## Fosse Green Energy Limited (the "Applicant") Development Consent Order (EN010154) (the "Application") Deadline 5 Submission

We refer to the Examining Authority's Rule 17 letter dated 2 April 2026 [PD-019] (the "**Rule 17 Letter**"). We refer further to the Examining Authority's third written questions issued on 23 April 2026 [PD-021] ("**ExQ3**").

## 1. **AC Interference Modelling Data / Timeline**

FIGURE TITLE  
400KV PIPELINE CROSSING  
FIGURE NUMBER  
Figure 1-1  
DOCUMENT REFERENCE  
EN010154/APP/X.X

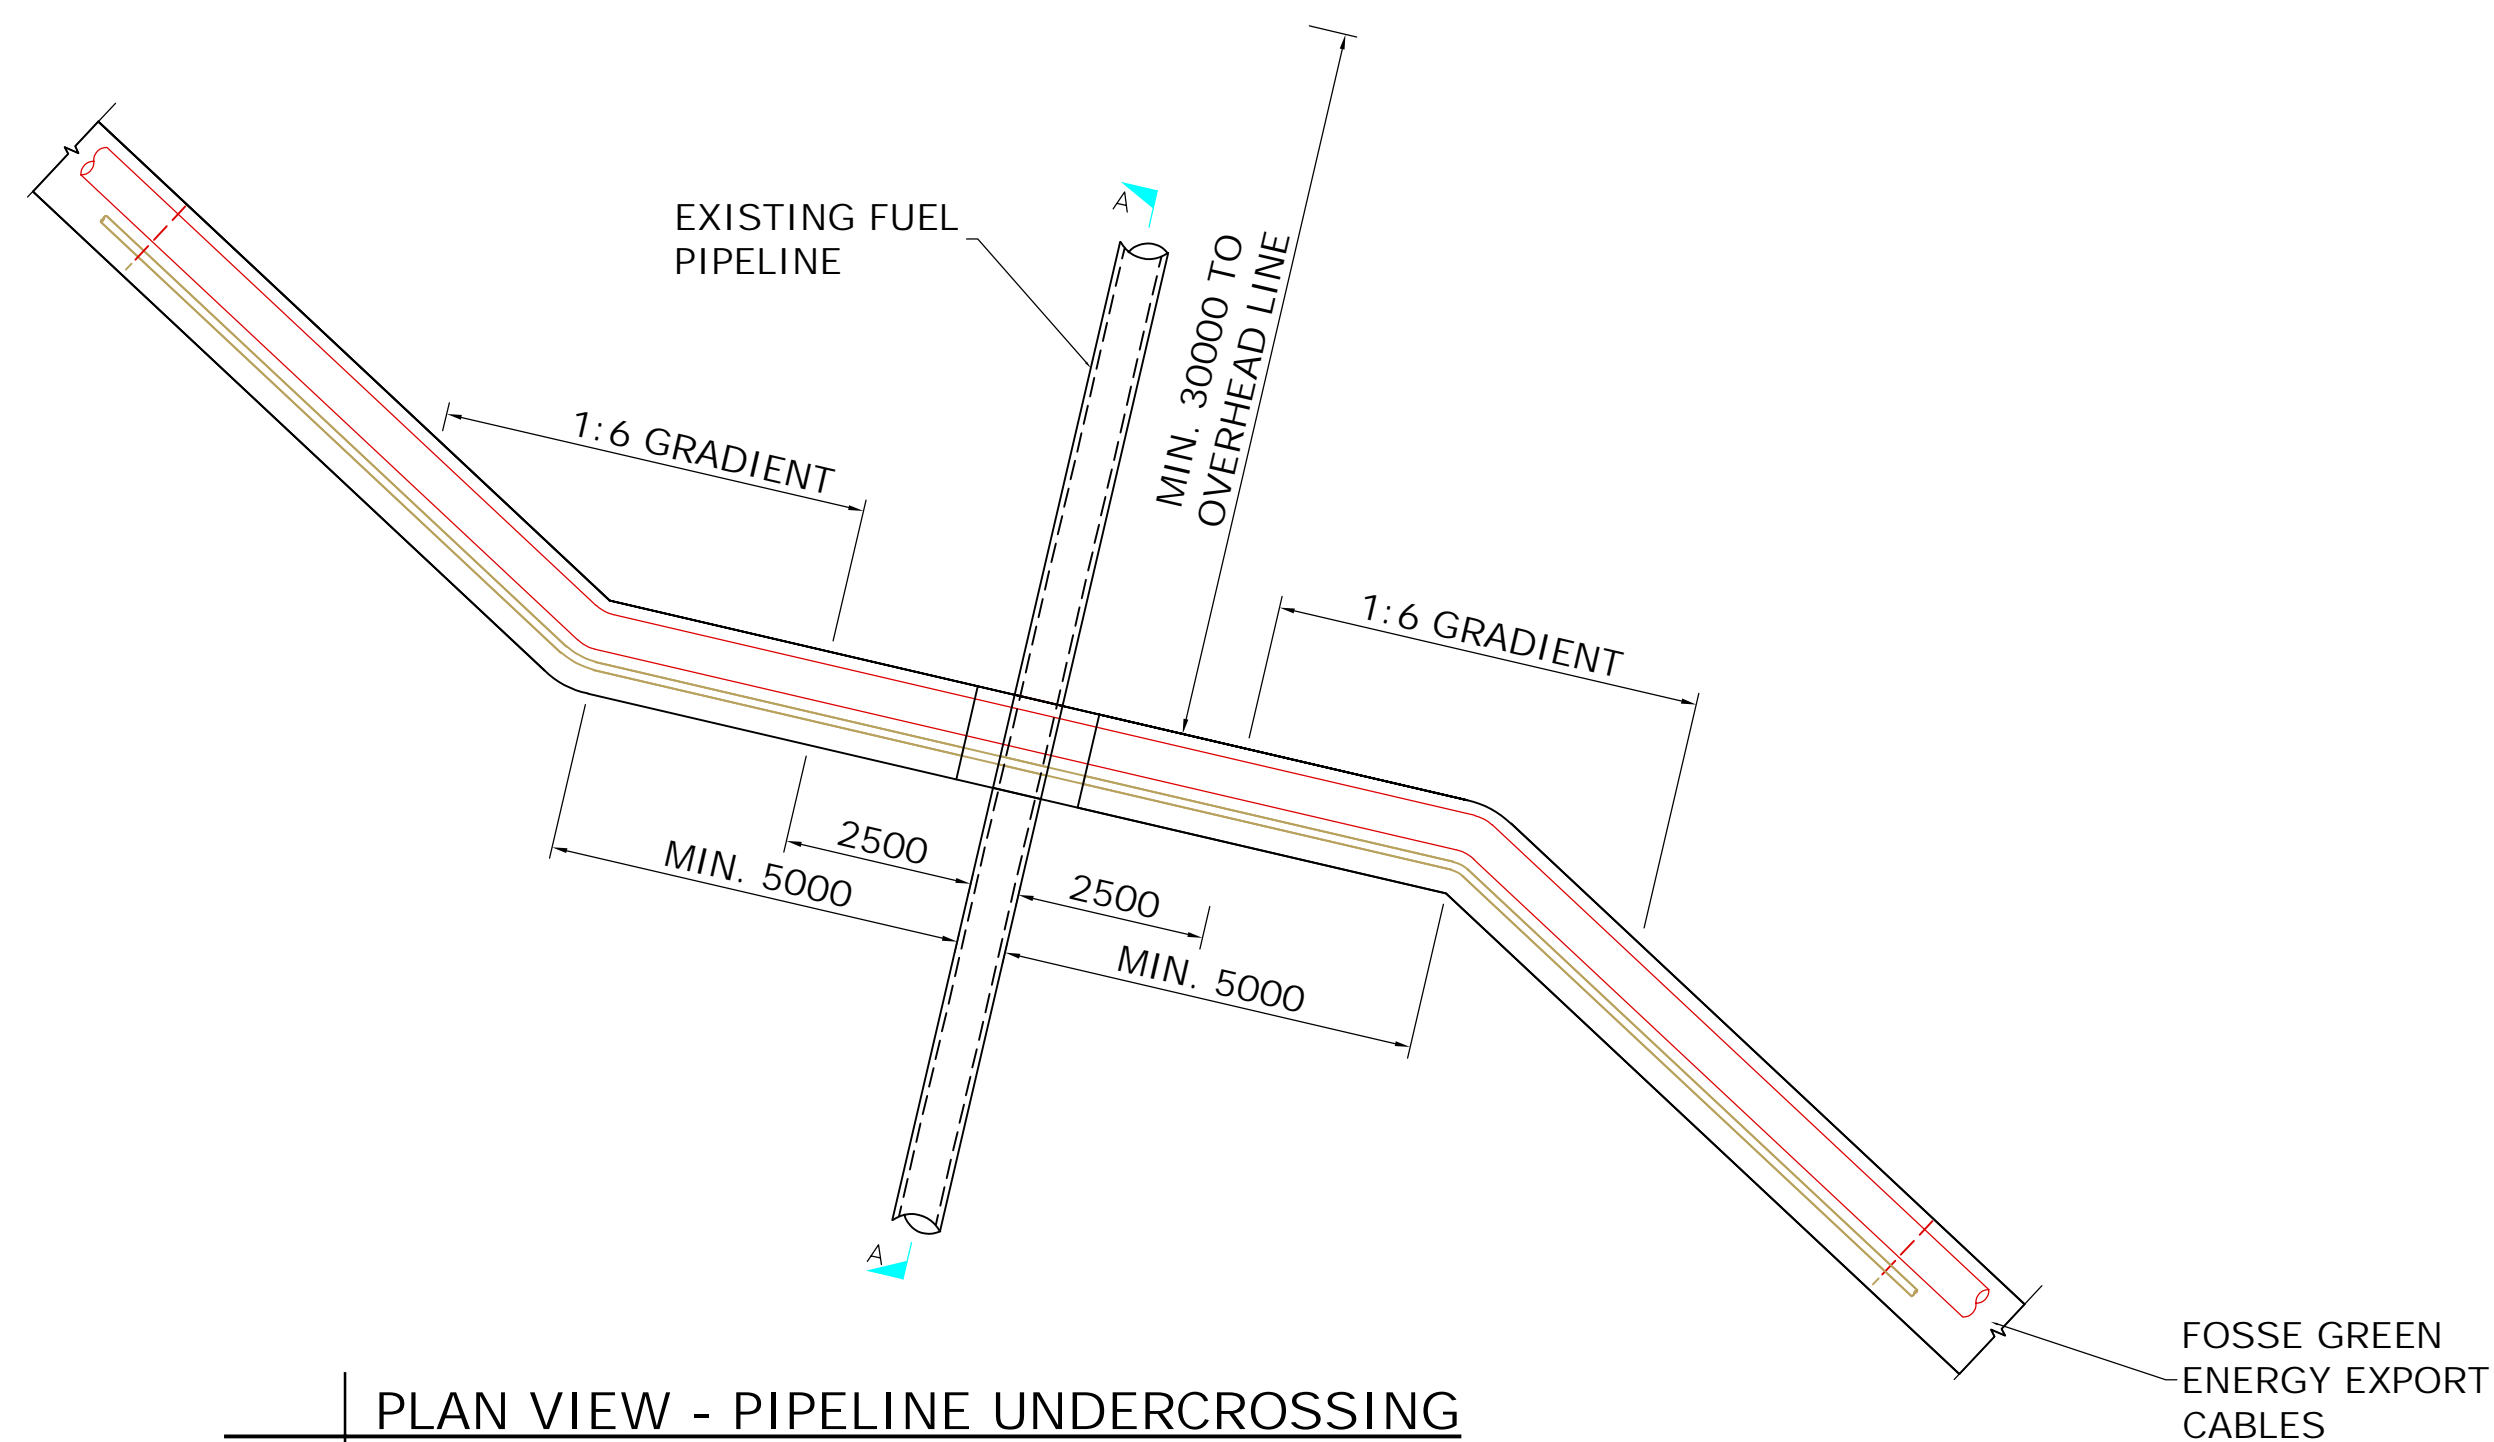
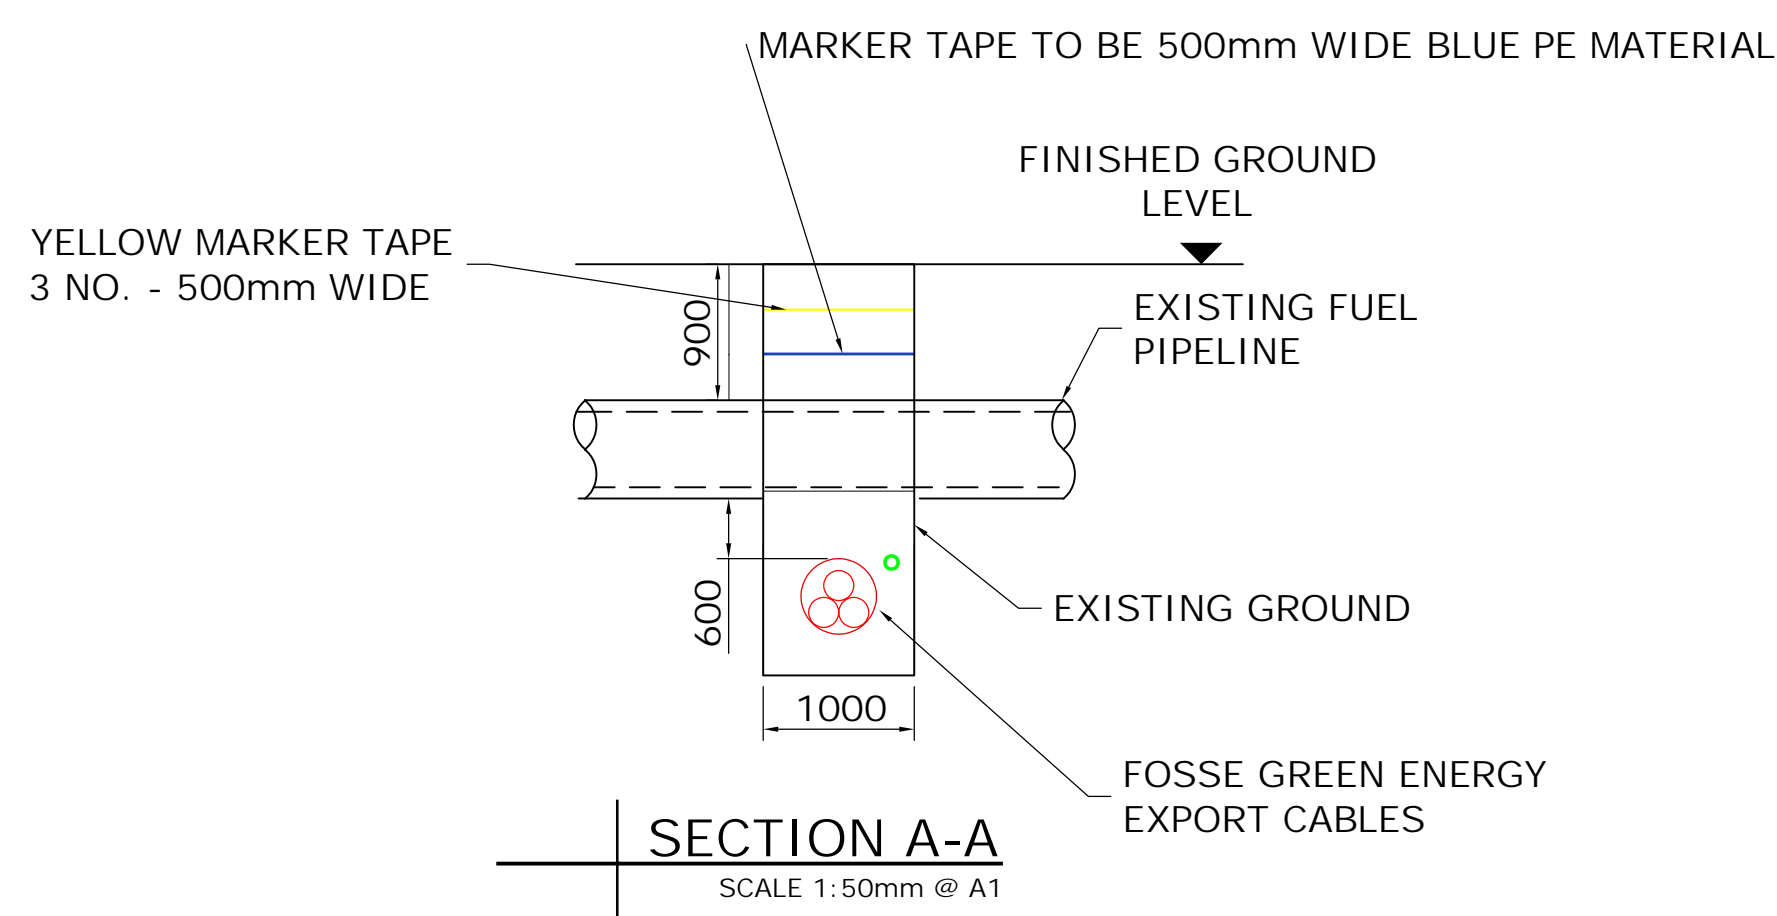
- 1.1 BPA were provided with updated AC Interference Modelling Report on 15 April 2026 at 16:09. Such data was insufficient as outlined in an email from BPA to AECOM dated 21 April 2026 timed at 13:16.
- 1.2 On 24 April 2026 at 16:24, AECOM provided an updated AC Interference Modelling Report which included indicative crossing drawings. However, such data still remained insufficient in respect of

the exact parameters for the cable and where any transition from trefoil to flat formation is to be carried out.

1.4 P66/BPA are in principle happy with the AC Interference Modelling Report and the therein embedded outline specification at Appendix 'C' and 'D' thereof (together comprising the "P66 outline specification" (enclosed herewith)) but note that the P66 outline specification currently incorrectly refers to the Pipeline as a "gas pipeline" and should be amended.
